KIRKLEES METROPOLITAN COUNCIL INVESTMENT & REGENERATION SERVICE

DELEGATED DECISION TO DETERMINE PLANNING APPLICATION FOR ADVERTISEMENT CONSENT

Reference No:	2024/64/93530/W
Site Address:	Kingsgate Centre, King Street, Huddersfield, HD1 2QB
Description:	Advertisement Consent for erection of illuminated and non-illuminated signs (within a Conservation Area)
Recommending Officer:	Joanna Rednall

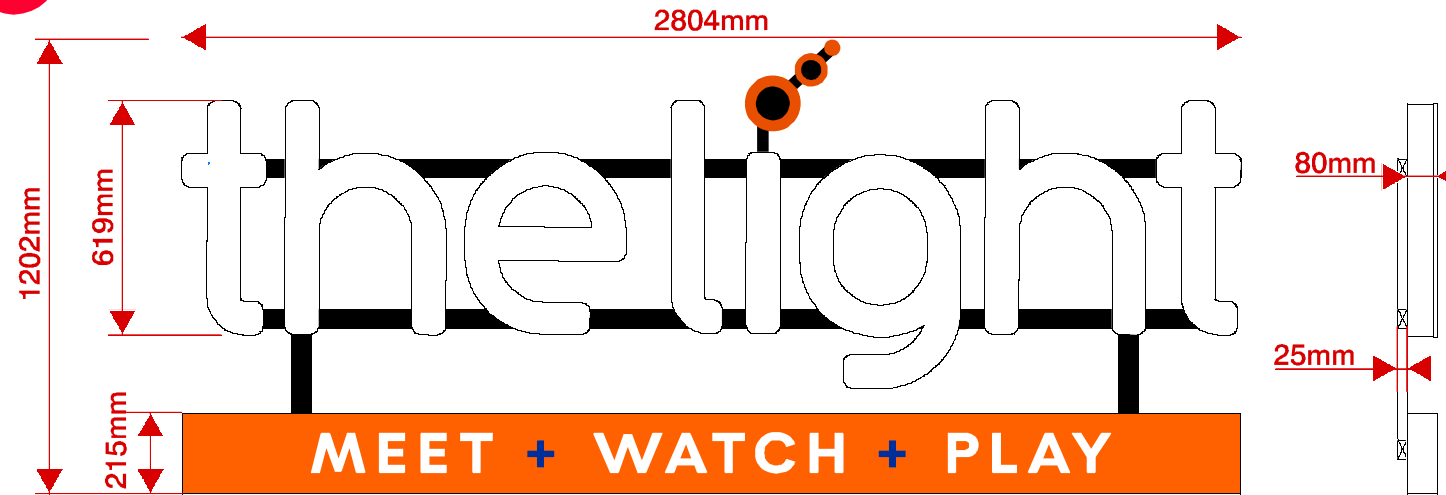
Sign A is proposed to a prominent location within Huddersfield Town Centre Conservation Area. Initially, Sign A consisted of an internally illuminated sign; however, this illumination has been removed and the sign is proposed as non-illuminated. As a result, sign A's proposed design and scale are considered to be in keeping with the character of the conservation area and wider street scene. Cross Church Street is characterized of commercial units featuring a variety of non-illuminated signage and window displays, therefore the introduction of Sign A would appear sympathetic and in keeping with the character of the street scene.

Cross Church Street Elevation

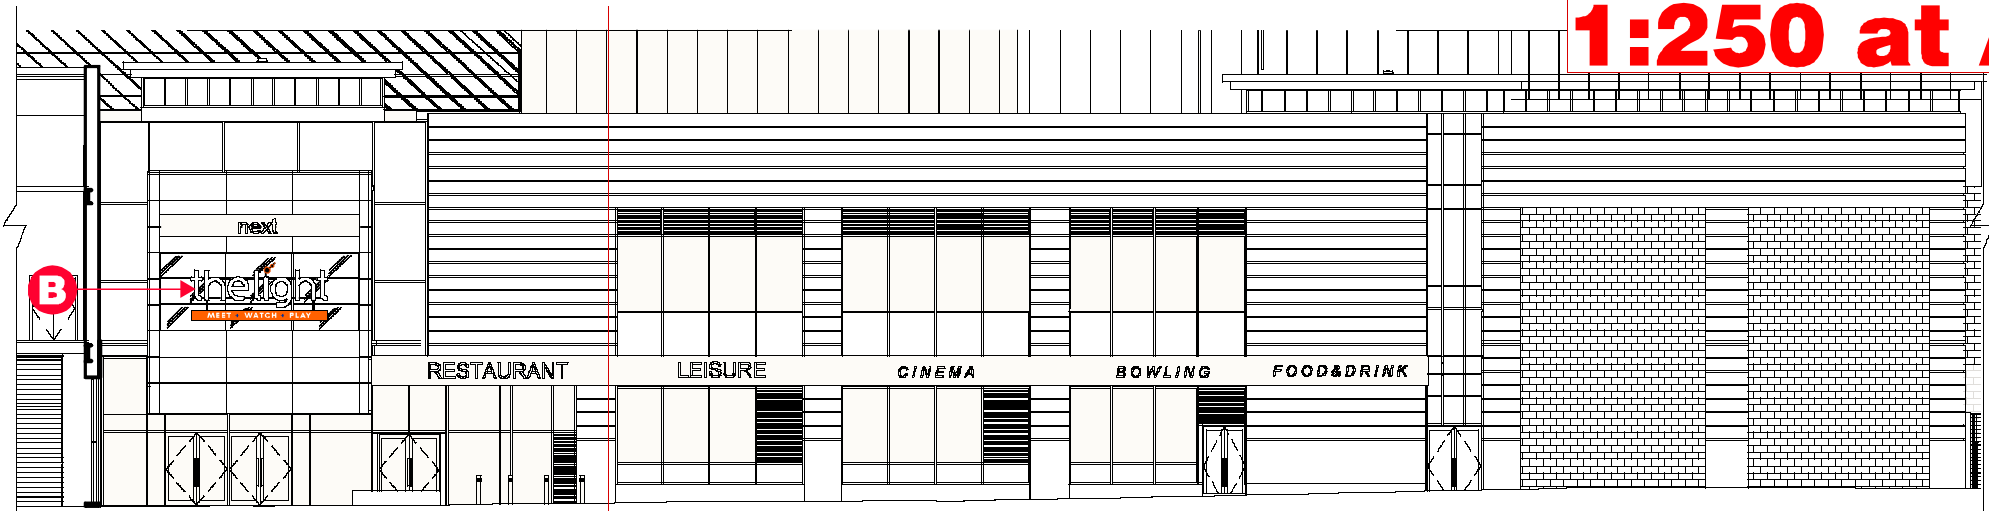
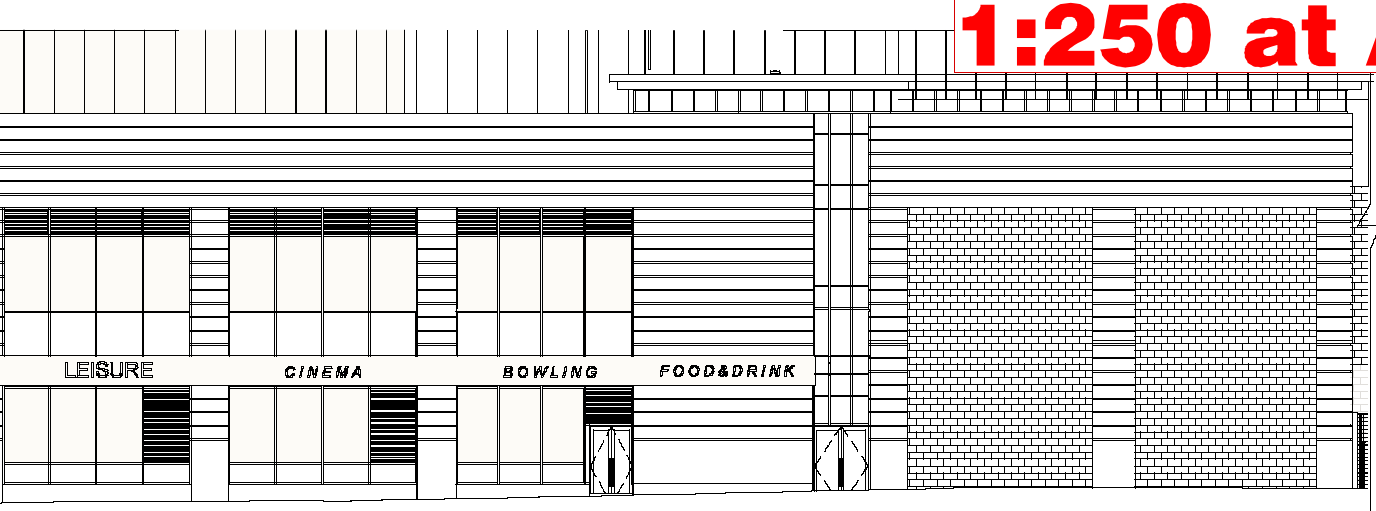
With regard to sign B and E, Conservation officers raised concerns due to its sensitive location in conjunction with nearby listed buildings and requested justification for the introduction of internally illuminated signage on this elevation. The applicant has clarified that Sign B is intended for the main entrance of The Light, and the proposed plans show sign B will replace the existing House of Fraser signage on this elevation. In response to these concerns, the applicant has revised the proposal amending signs B & E to be externally illuminated via trough lighting, which is considered to be a less prominent form of illumination and suitably addresses the concerns raised by conservation officers. The amendment from internally to externally illuminated signage to this elevation is considered to be visually appropriate and neither overly oppressive or harsh and would not create a stark feature within the street scape.

In addition, the host building already has an established commercial use and has functioned as a shopping center for a significant amount of time with relevant signs to advertise this on the building. The submitted elevations show signs B and D would replace existing House of Fraser signage. As such, the proposed signs will harmonise with the new business use of the building and therefore, it is concluded that the signage would not appear out of keeping or negatively prominent within the wider street scene.

Shorehead Elevation

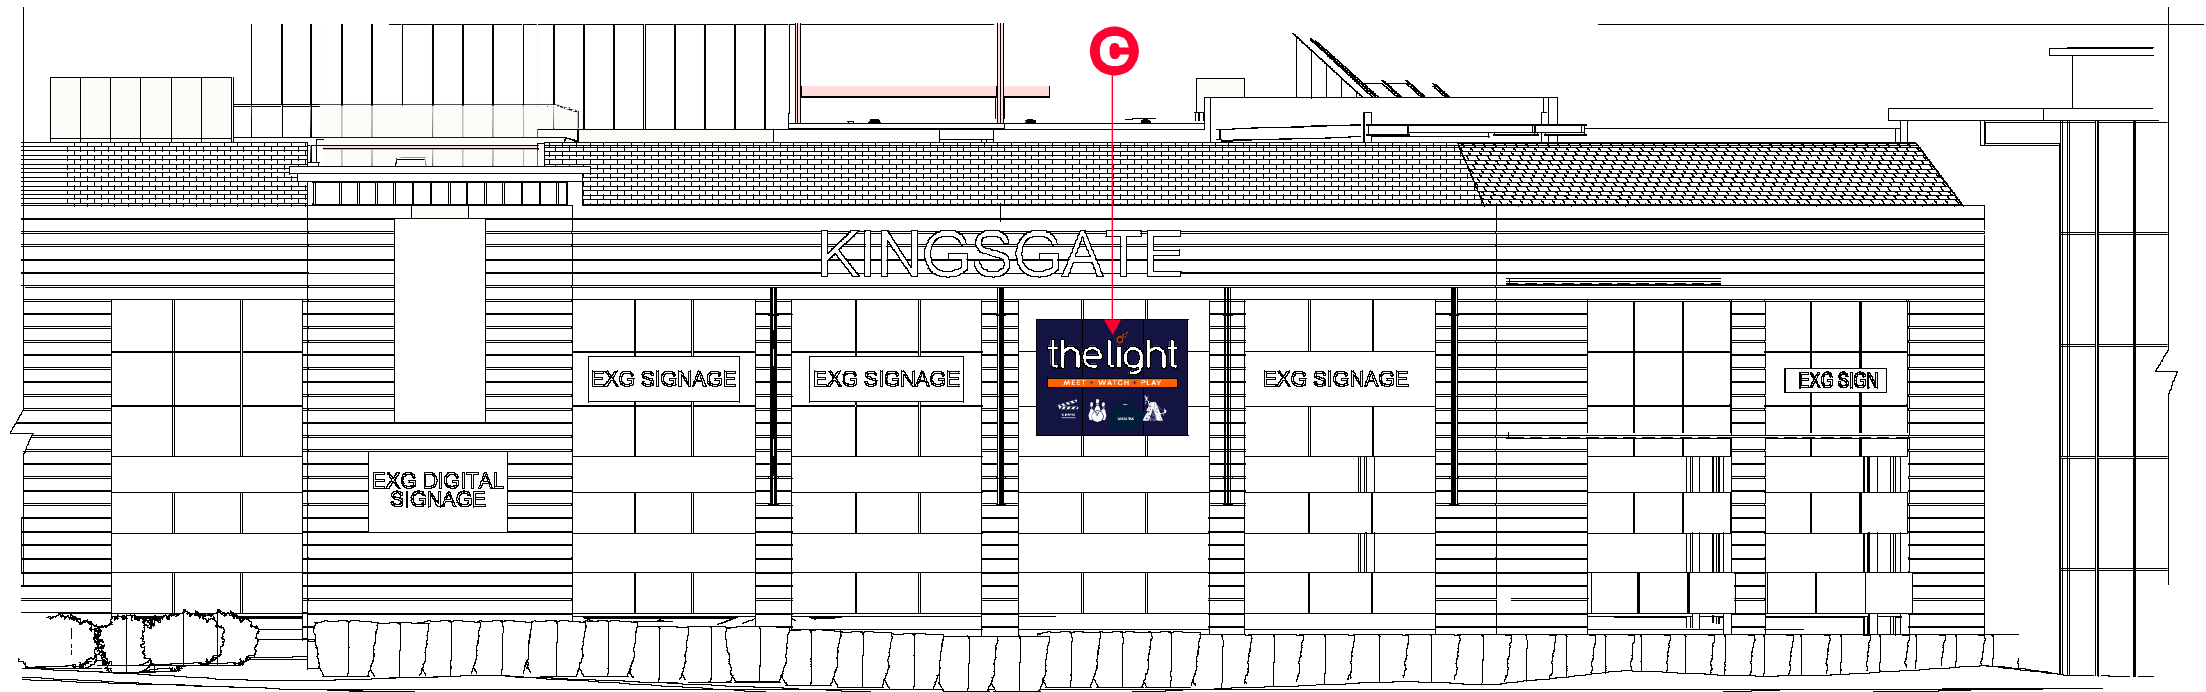
Sign C is considered to have an acceptable visual impact and Conservation officers have raised no concerns about its impact on heritage assets. Sign C is internally illuminated fascia sign comprising white text on a blue and orange background. This sign would be facing Shorehead Roundabout where there are examples of existing signage. As such, given the small scale of this sign

in relation to the host building, Sign C would not have a wholly negative impact on the wider street scene or upon the character and appearance of the conservation area.
